**Re: The Yards Kemps Creek Estate - Ardex Facility
 Responses to Additional Information Requests – SSD-25725029**

Further to your request we are pleased to provide our response to the civil items raised by DPIE and agencies as part of their information requests relating to SSD-25725029.

RETAINING WALL TYPE 2
(REINFORCED EARTH WALL)
SCALE 1:20

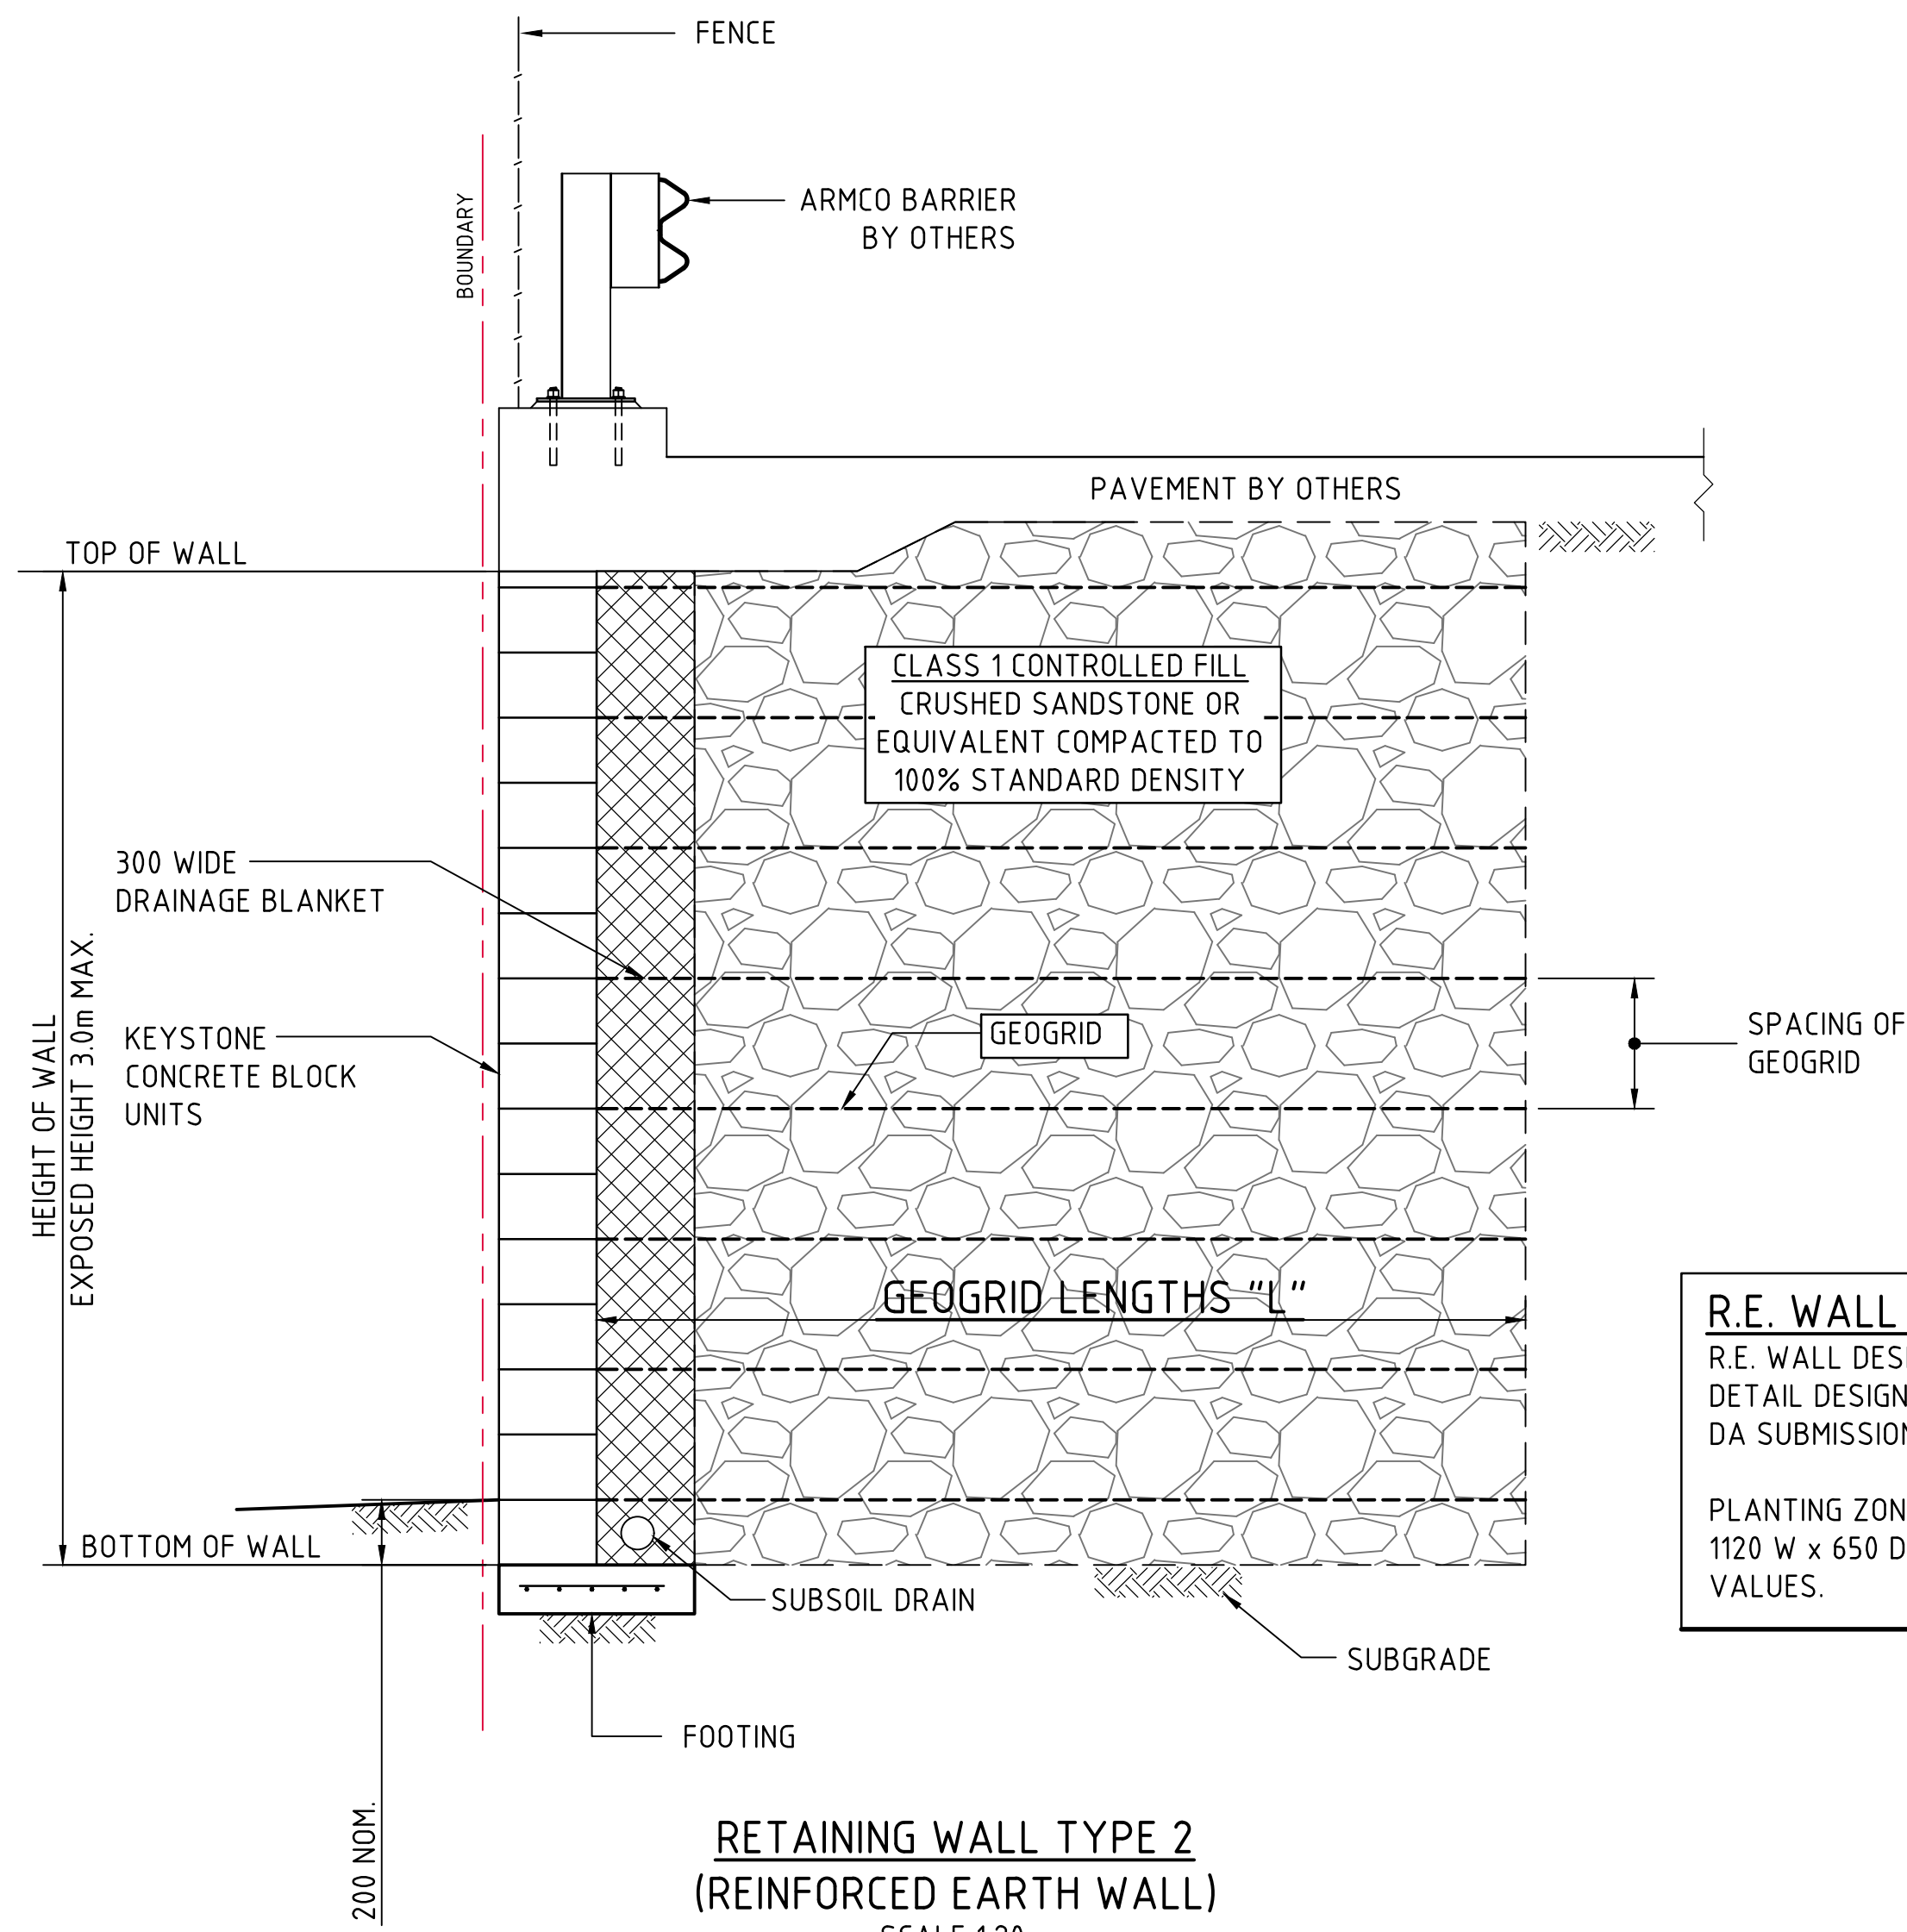
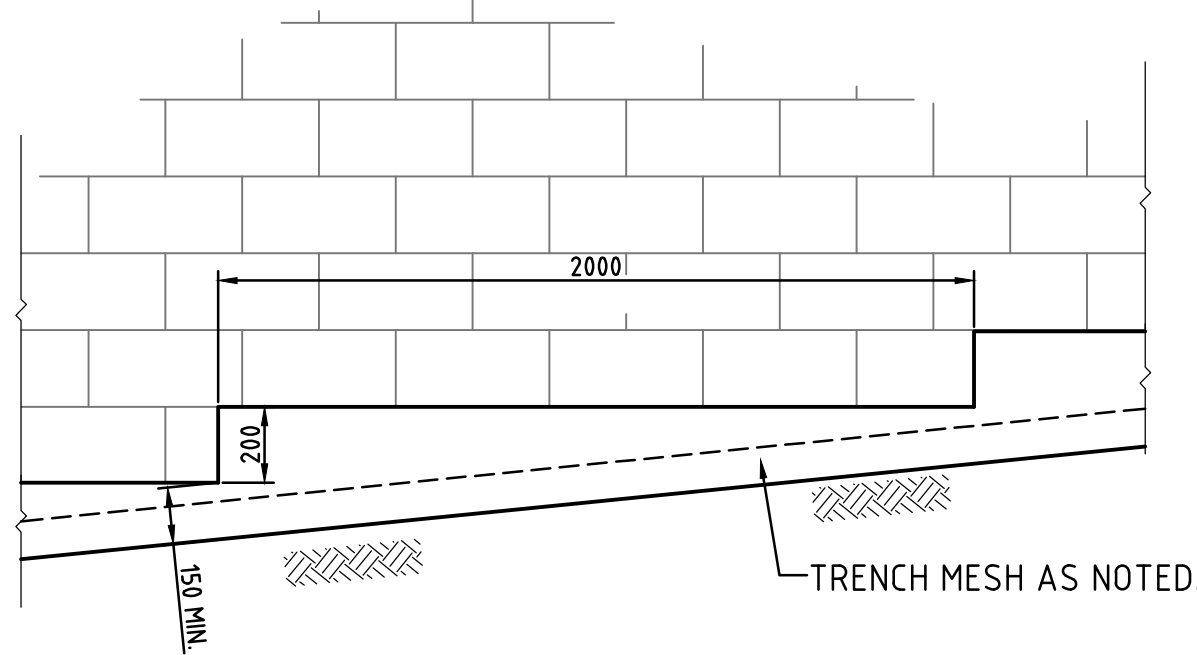
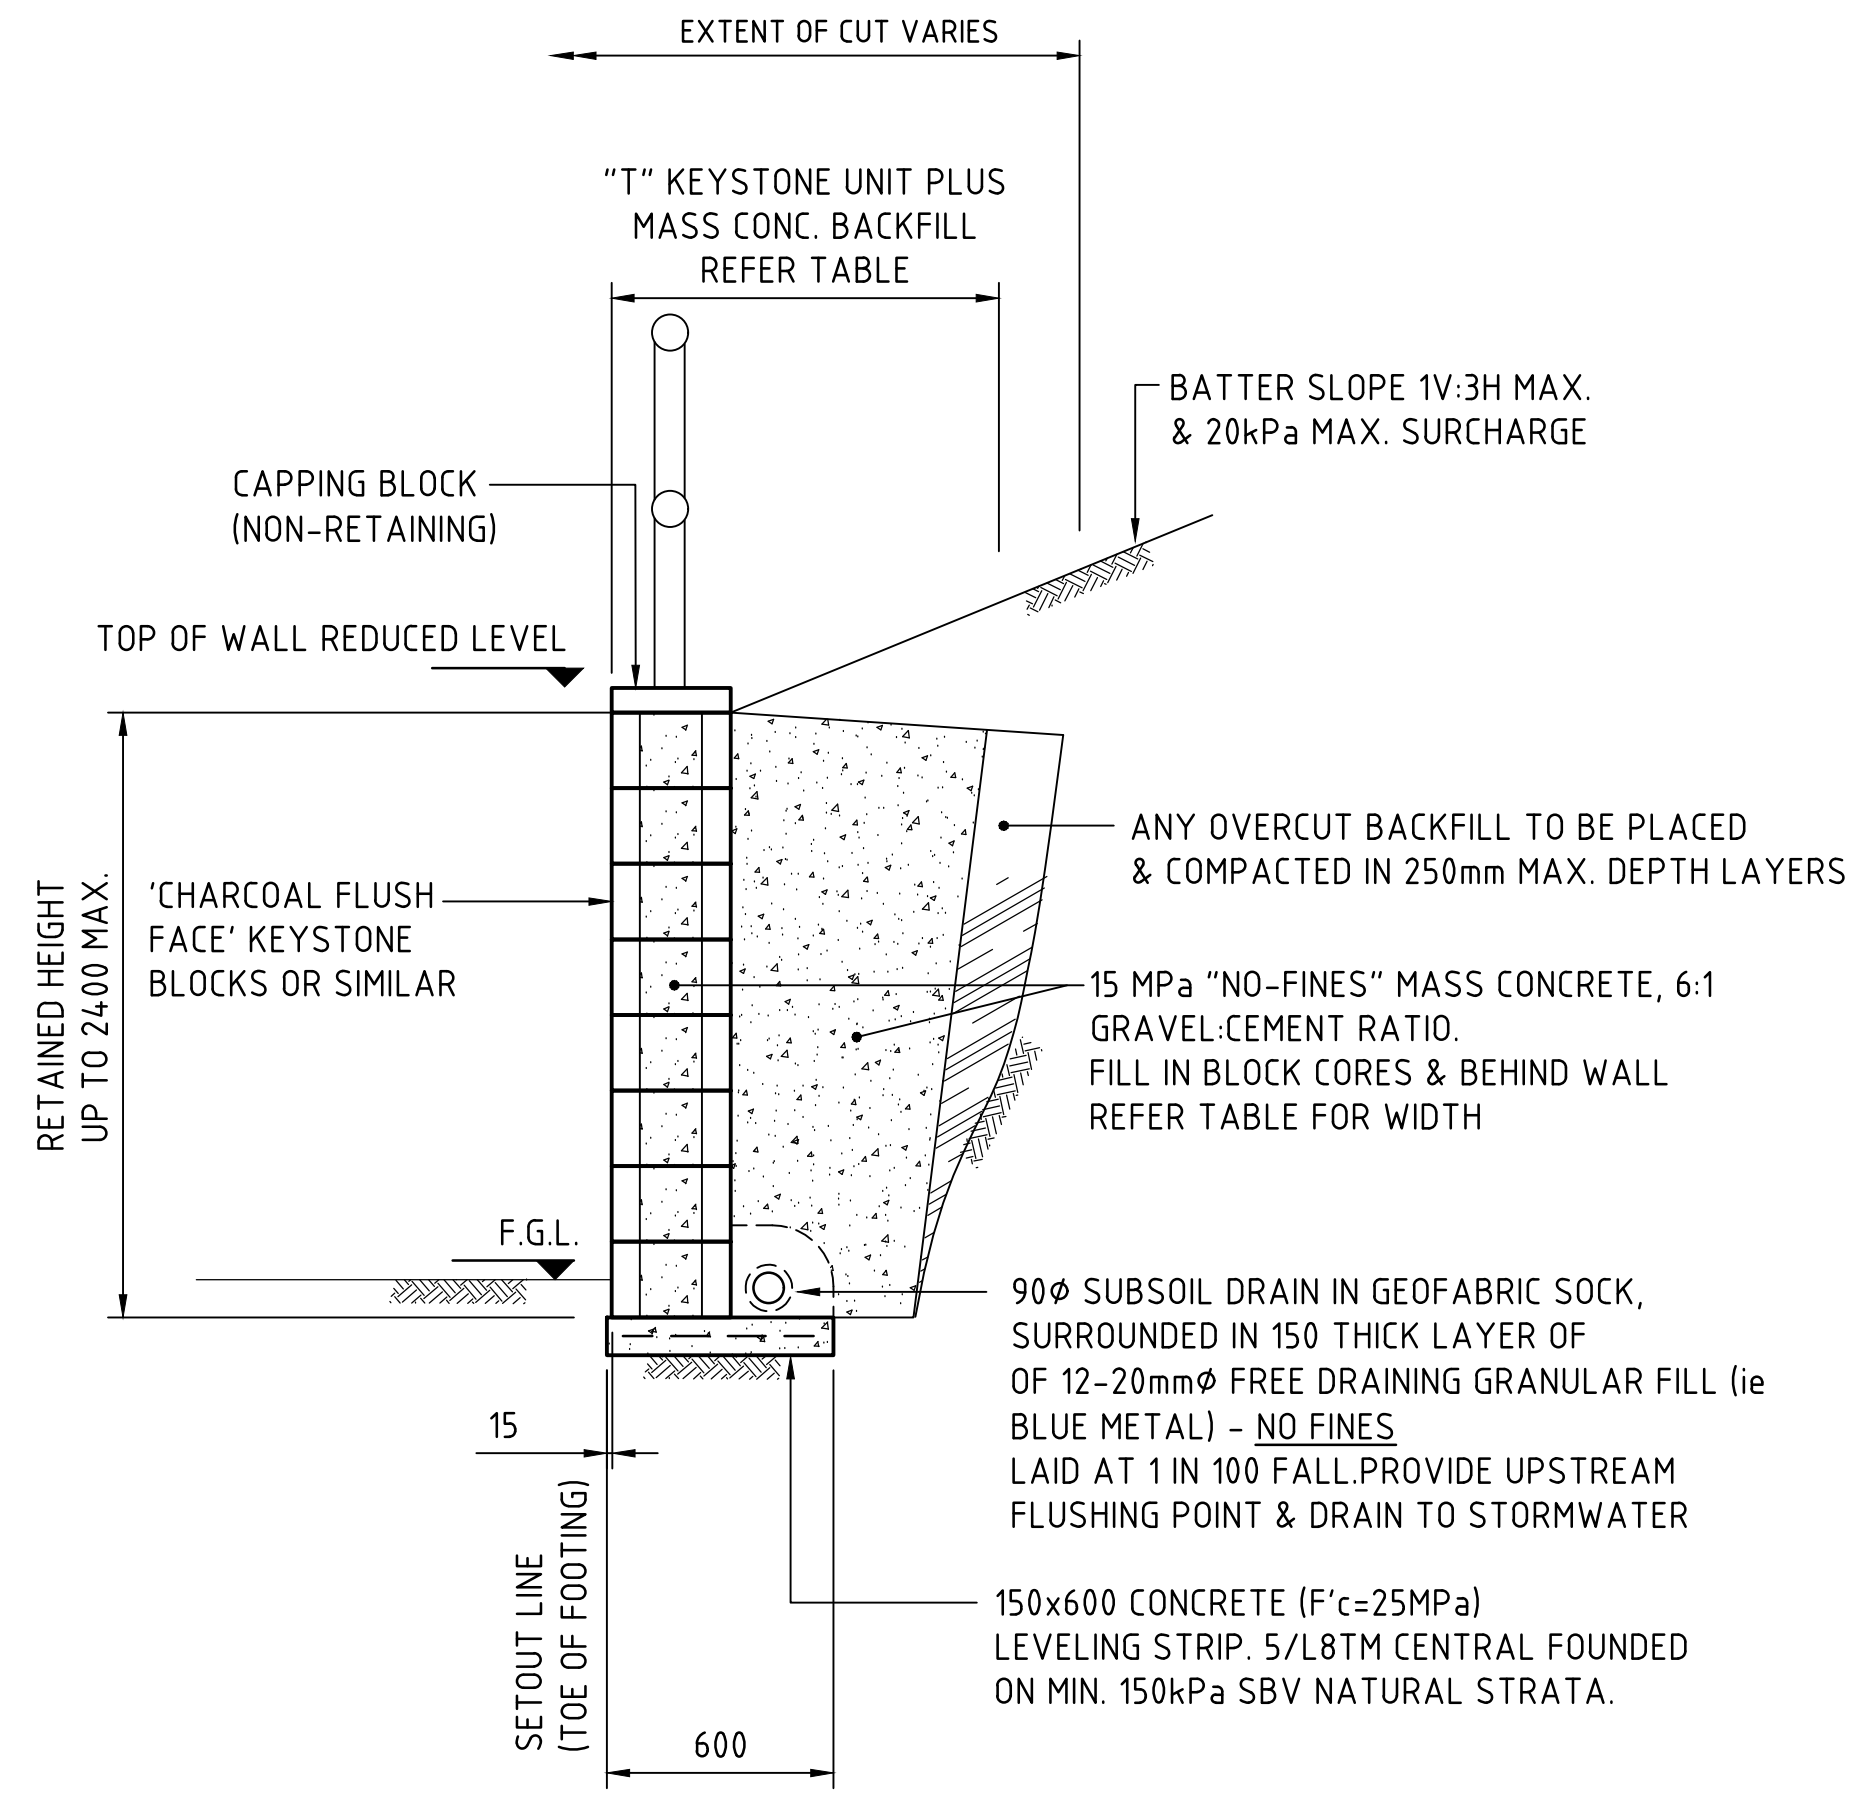
Item 2	<p><i>The Civil Report indicates that several retaining walls are proposed. These are not discussed / considered in the EIS. The Department requires that this detail is included in the RIS.</i></p> <p>RESPONSE</p> <p>Low height retaining walls are proposed as shown on drawing Co13362.05-SSDA50. Walls are noted to boundary and locally around garden beds. Walls fronting public domain are less than 1.2m and have been setback from the boundary in accordance with the DCP.</p> <p>We have prepared typical wall details and included these in the updated EIS documents.</p>
